The North Wales Wind Farms Connection Project

SP Manweb's Response to Late Deadline 1
representation from Eifion Bibby

Application Reference: EN020014

SP Manweb's Response to Late Deadline 1 representation from Eifion Bibby

SITE PLAN 2

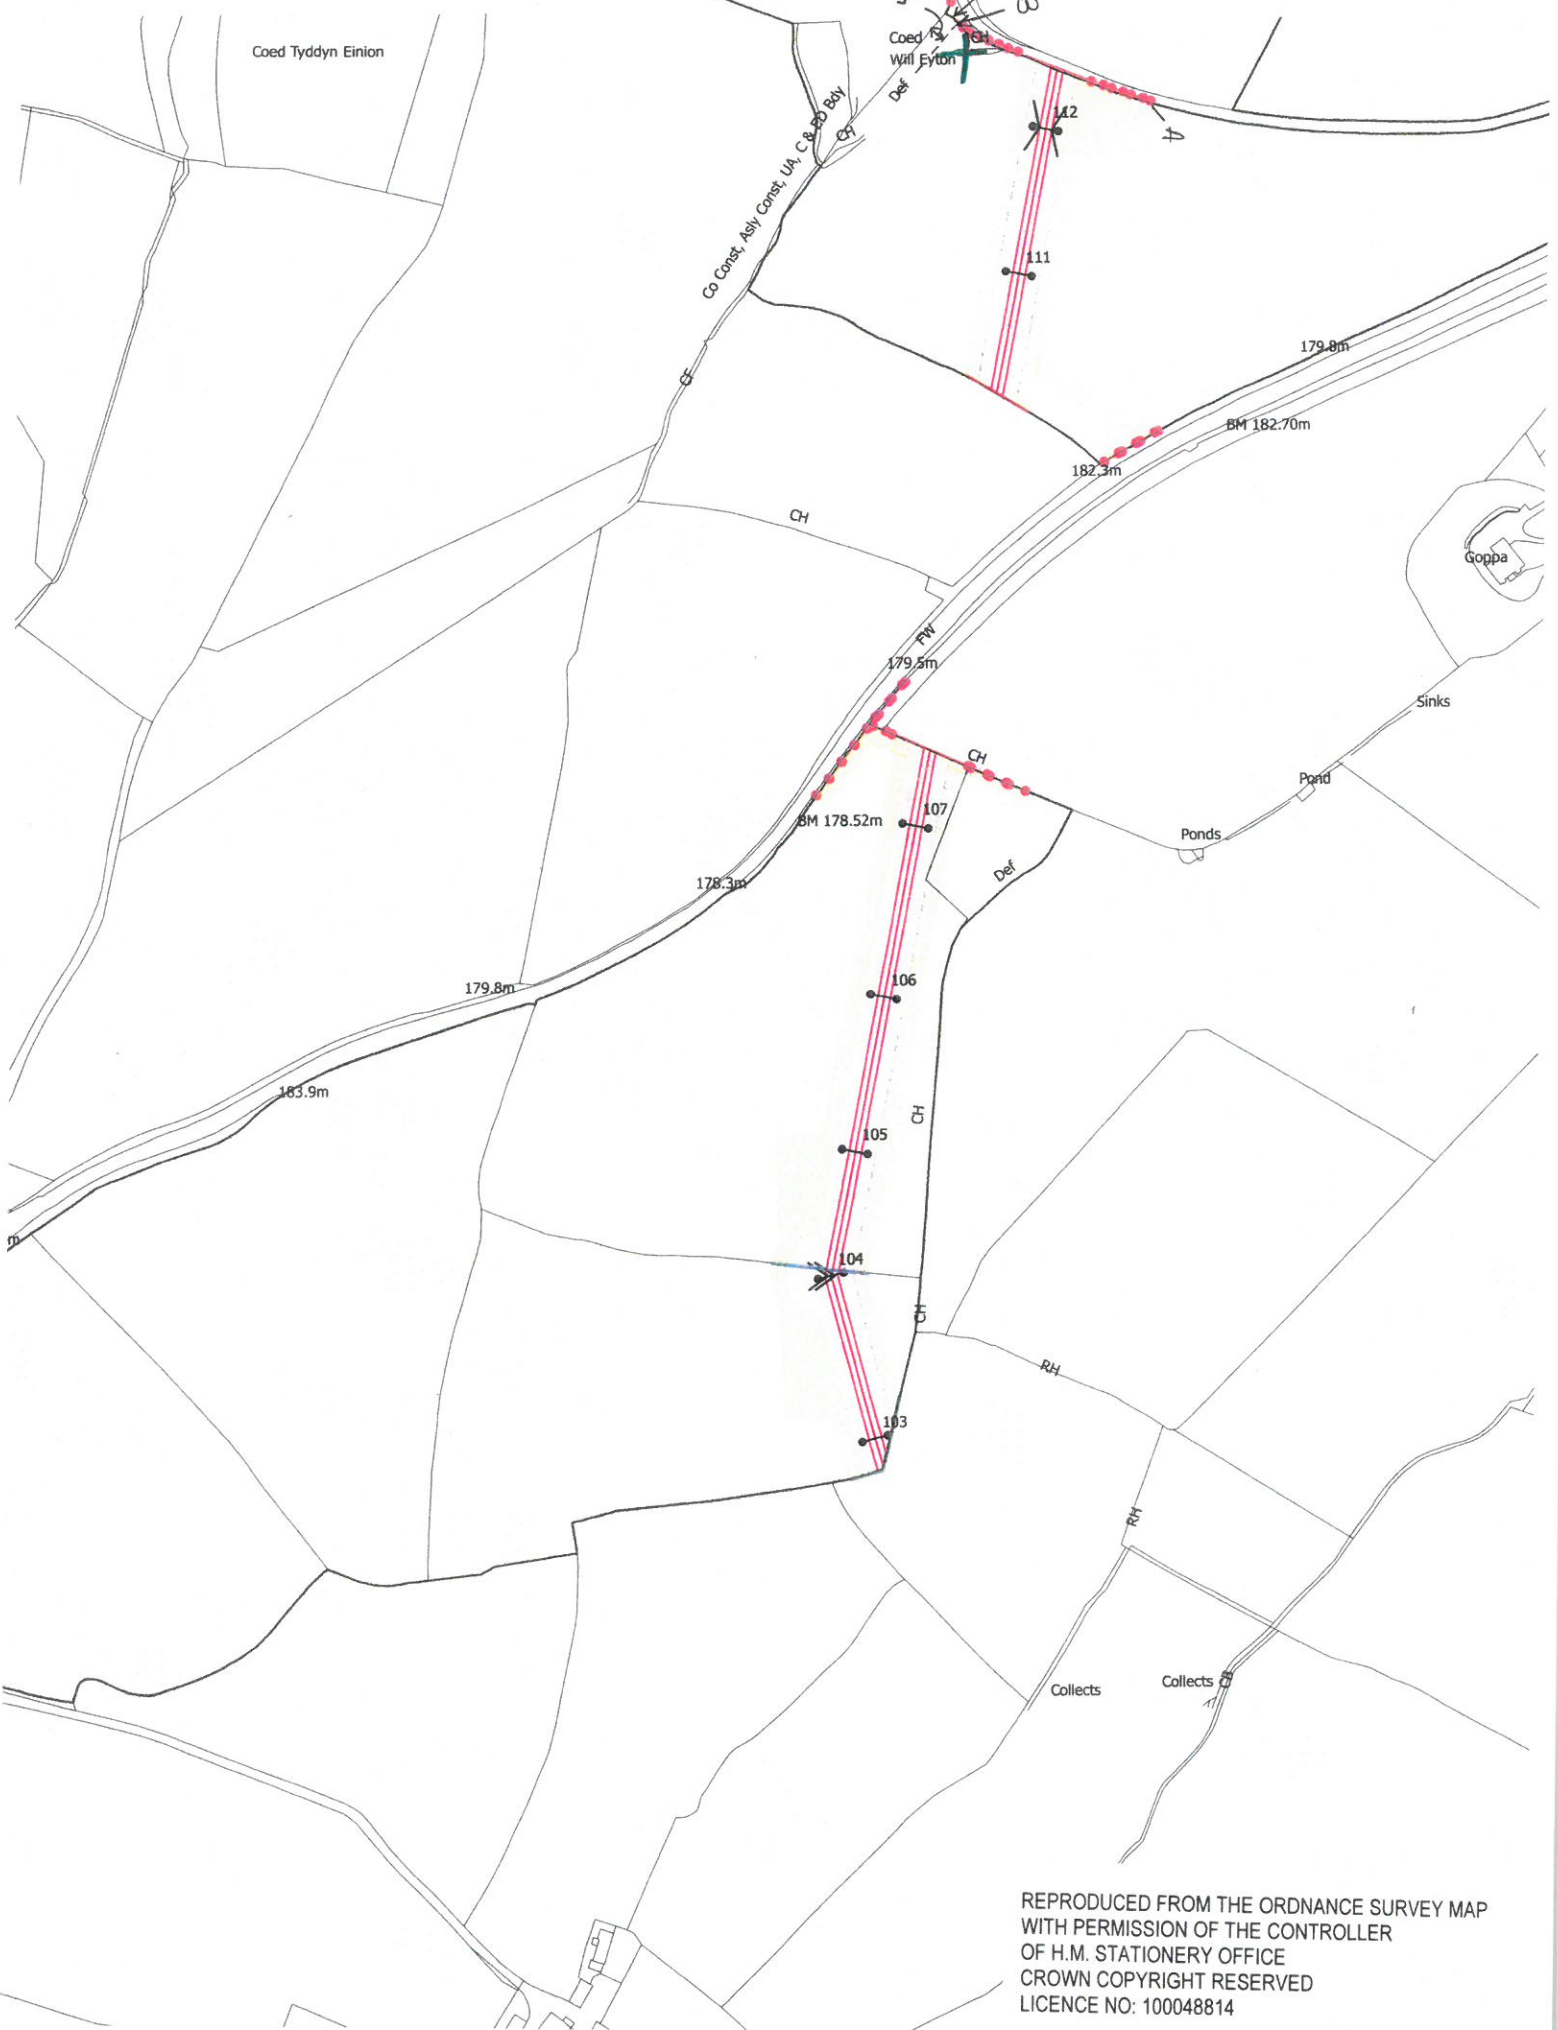
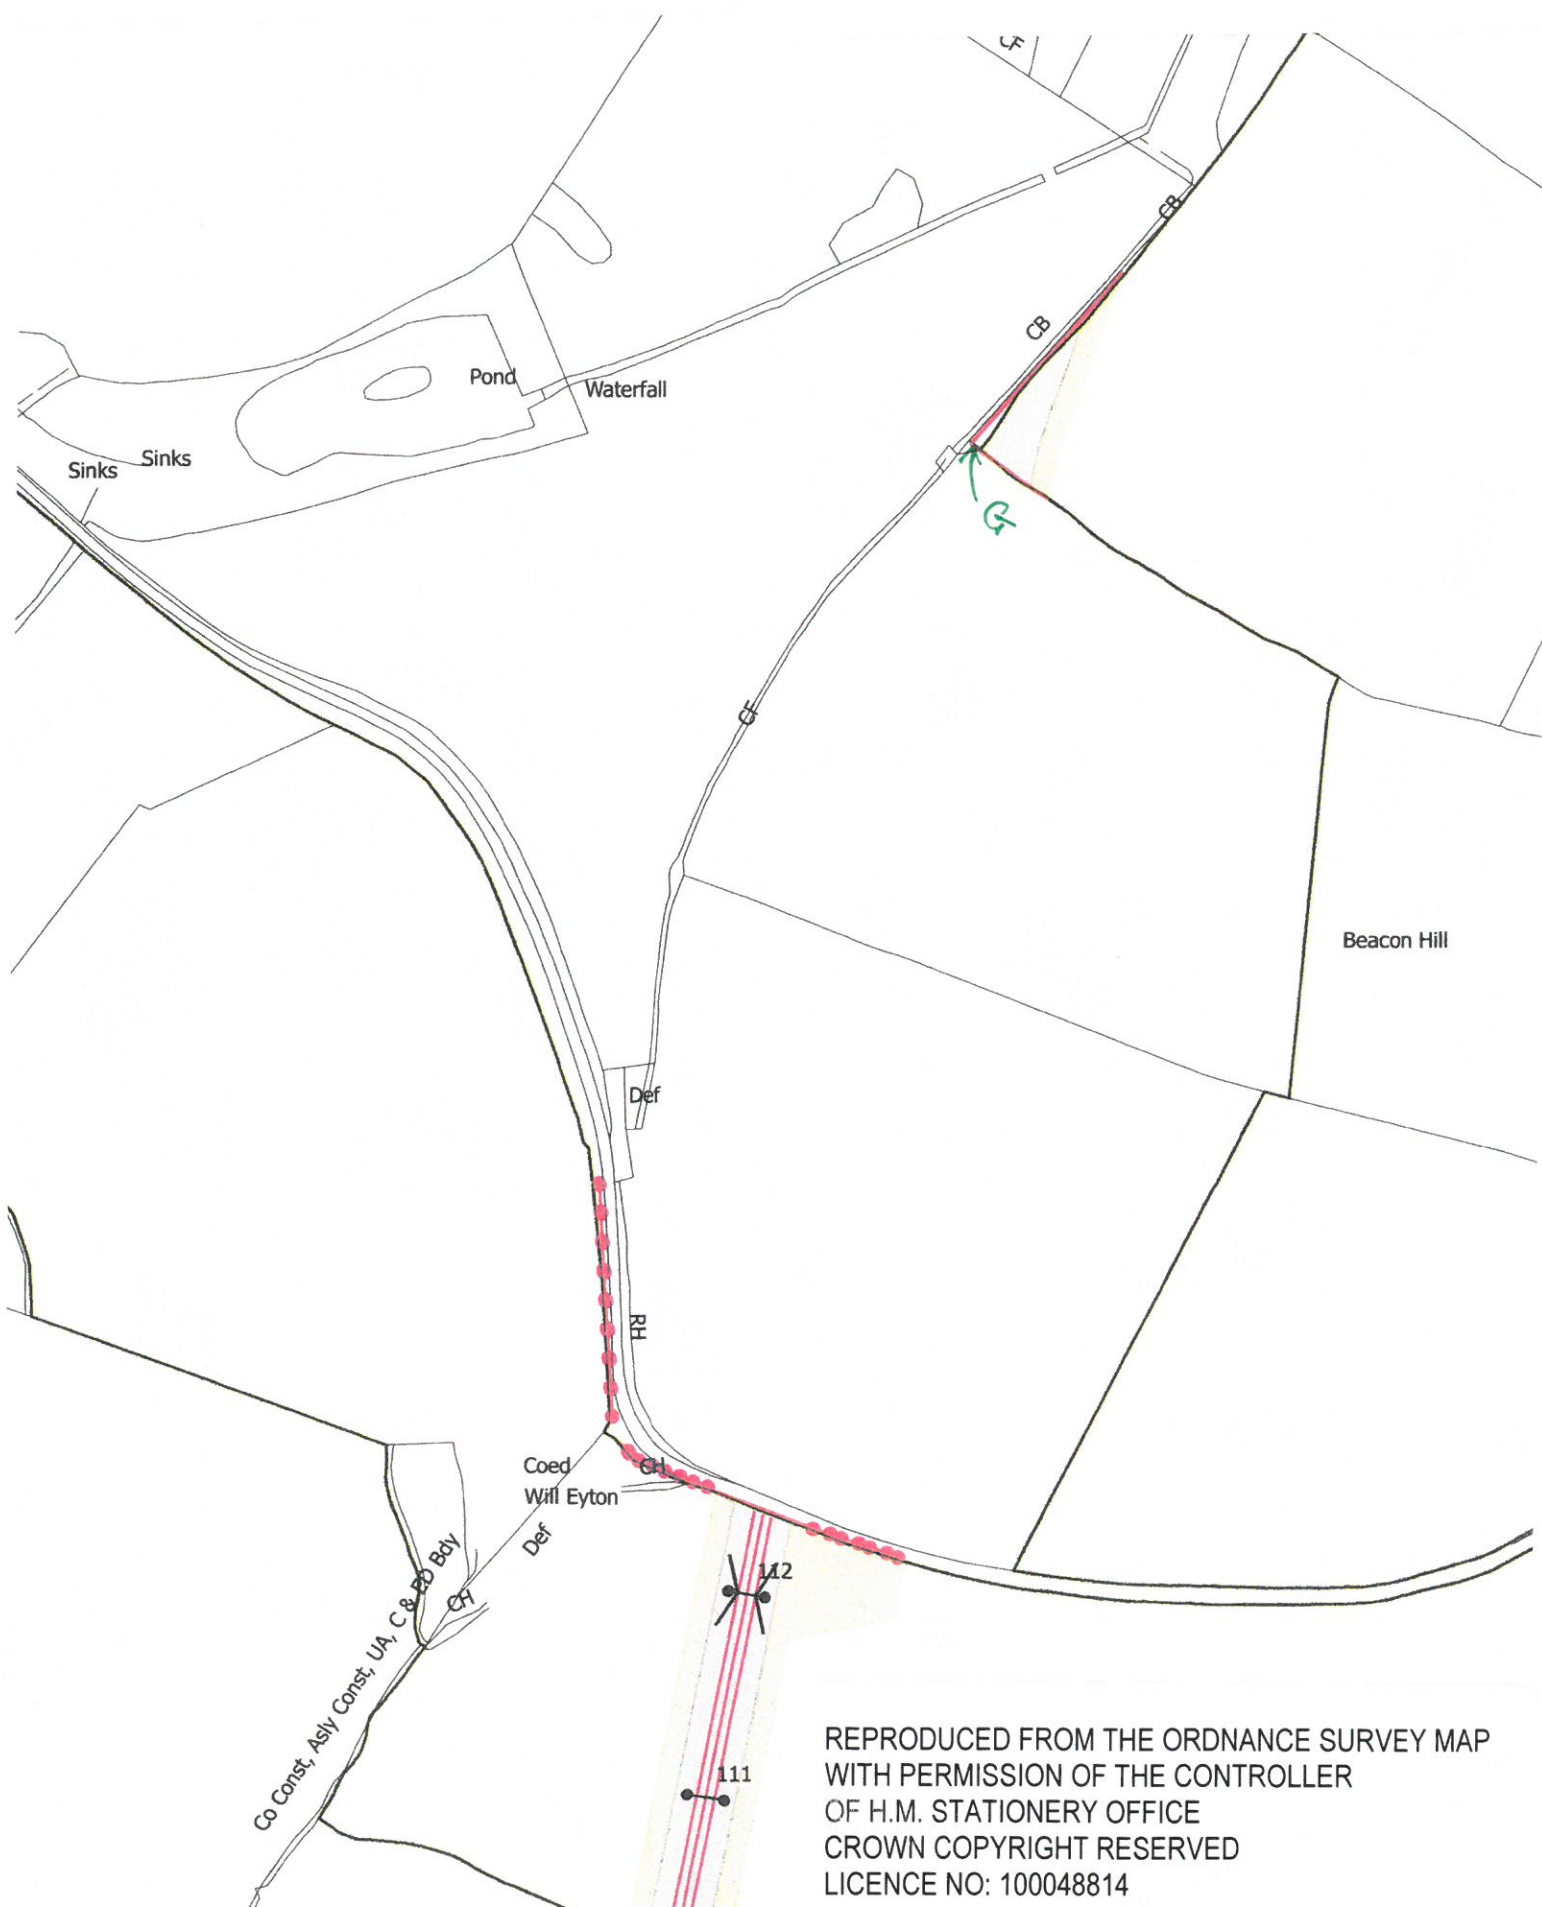
Respondent	Written Representation	SPM Response (in relation to matters that concern Option A only)
<p>Eifion Bibby on behalf of Messrs EW, PA and EW Hughes</p>	<p>Dear Sir,</p> <p>Further to our telephone conversation of earlier today , in respect of Scottish Power’s Option A proposal, we confirm that our above mentioned client has asked that we request the Planning Inspectorate ,please, to visit the subject affected land in their ownership so as to be in a position to comprehend the requests made for the following modifications to the scheme proposal -:</p> <p>A. In order to reduce the significant impact of the proposed scheme on agricultural use of the subject silage/arable land, our client is seeking:</p> <ol style="list-style-type: none"> 1. that proposed poles 112 can be located due west adjoining the 5m wide field access track ,but not obstructing the same and existing field gate (and abutting the northerly perimeter of the arable land)as approximately shown in green by “x” on appended Site Plan 1. 2. that the existing field gateway as approximately shown in green by “ G” on attached Site Plan 2 will not be obstructed by proposed poles 117. <p>B. That access rights, along the driveway in the direction of Eriviat Hall, to Messrs Hughes’ agricultural land are not extinguished and suitable temporary alternative access measure are provided during any affected period.</p> <p>C. That no trees will be planted along the A543 roadside boundaries owing to concerns regarding the effects on</p>	<p>Points 1 and 2 relate to Option B and will be responded to separately.</p> <p>Access to Eriviat Hall</p> <p>SP Manweb is currently negotiating the terms of an agreement with these individuals which would require SP Manweb to implement measures to protect these access rights. In any event, under the terms of the Order (Article 23), access rights would only be suspended and unenforceable or, where so notified by SP Manweb, extinguished in so far as their continuance would be inconsistent with the exercise of the right created and acquired. The rights SP Manweb is seeking over the driveway are not inconsistent with the existing access rights and therefore the existing access rights would not be suspended or extinguished.</p> <p>Landscaping impacts</p> <p><u>Tree Planting</u></p> <p>Requirement 5 of the development consent order has been updated to accord with discussions during the hearings. It applies to the planting to take place on the dark green land and the dark green stippled land shown on the Land Plans.</p> <p>The dark green land on the Land Plans are the areas where new trees, shrubs and other soft landscaping is proposed (Class 3 Rights) for enhancement or mitigation purposes.</p>

<p>highway safety and the liability for the future maintenance cost of such trees abutting the highway (to account for a tree surgeon and to include traffic management controls) . Also it is our clients preference that no trees are planted abutting the driveway leading to Eriviat Hall and on non roadside boundaries abutting the subject land owing to enhanced difficulties & cost resulting in the maintenance of such perimeters as well as reduced productivity owing to canopy shading of prime agricultural land. Our client is content for hedge plants to be located along the perimeter as approximately shown between points A-B on appended Site Plan 1 (on the basis ,of course, that the access gate is not obstructed) .</p> <p>To confirm inspection arrangements, Messrs EW Hughes can be contacted on _____.</p> <p>We ask that the contact numbers, please, are retained confidentially.</p> <p>Yours faithfully,</p>	<p>The requirement provides that SP Manweb will submit to the relevant planning authorities for approval a written landscaping scheme (following consultation with relevant landowners). There will also be a maintenance scheme for this planting, again to be approved by the relevant planning authorities.</p> <p>The stipple green over the yellow land on the Land Plans are the areas where new trees, shrubs and other soft landscaping is proposed (for enhancement or mitigation purposes) which is on land that will be used for temporary construction works (Class 2 and Class 3 Rights). This planting will be subject to the same provisions as in relation to the dark green land on the Land Plans.</p> <p>The relevant planning authorities, therefore, are the final arbitrators over where new planting should be located.</p> <p>Requirement 7 of the development consent order has been updated to accord with discussions during the hearings. It applies to the planting to take place on the blue and yellow land shown on the Land Plans. The yellow land and blue land on the Land Plans are the areas where reinstatement planting is to take place (i.e. where hedgerows have been removed to enable the construction of the Proposed Development, these hedgerows will be reinstated).This reinstatement may also include improvements to vegetation; e.g. where a hedgerow had gaps, the Applicant would intend to restore those gaps.</p> <p>This reinstatement planting can only include improvement measures on the blue and yellow land where agreement has been reached with the relevant landowner over the improvement measures.</p>

<p><u>Maintenance</u></p> <p>SP Manweb will be responsible for maintaining the planting carried out under requirements 5 and 7 for a period of years as is agreed with the relevant planning authorities (a minimum of 5 years). After the agreed period, the landowner would have the responsibility for maintaining the planting. The cost of this maintenance would either be included in any negotiated voluntary agreement or would form part of the compensation claim should SP Manweb need to utilise the compulsory acquisition powers in the Order.</p> <p><u>Canopy Shading</u></p> <p>In relation to the impacts of landscaping on agricultural productivity resulting from canopy shading, we refer to Document reference SPM NWWFC Comments on WRs (REP2-015), , which notes that it is a generally accepted agricultural principle that trees and woodland can make a contribution to agriculture, including providing shade and shelter, prevention of erosion, protection of water resources, as well as having conservation and wildlife benefits.</p>
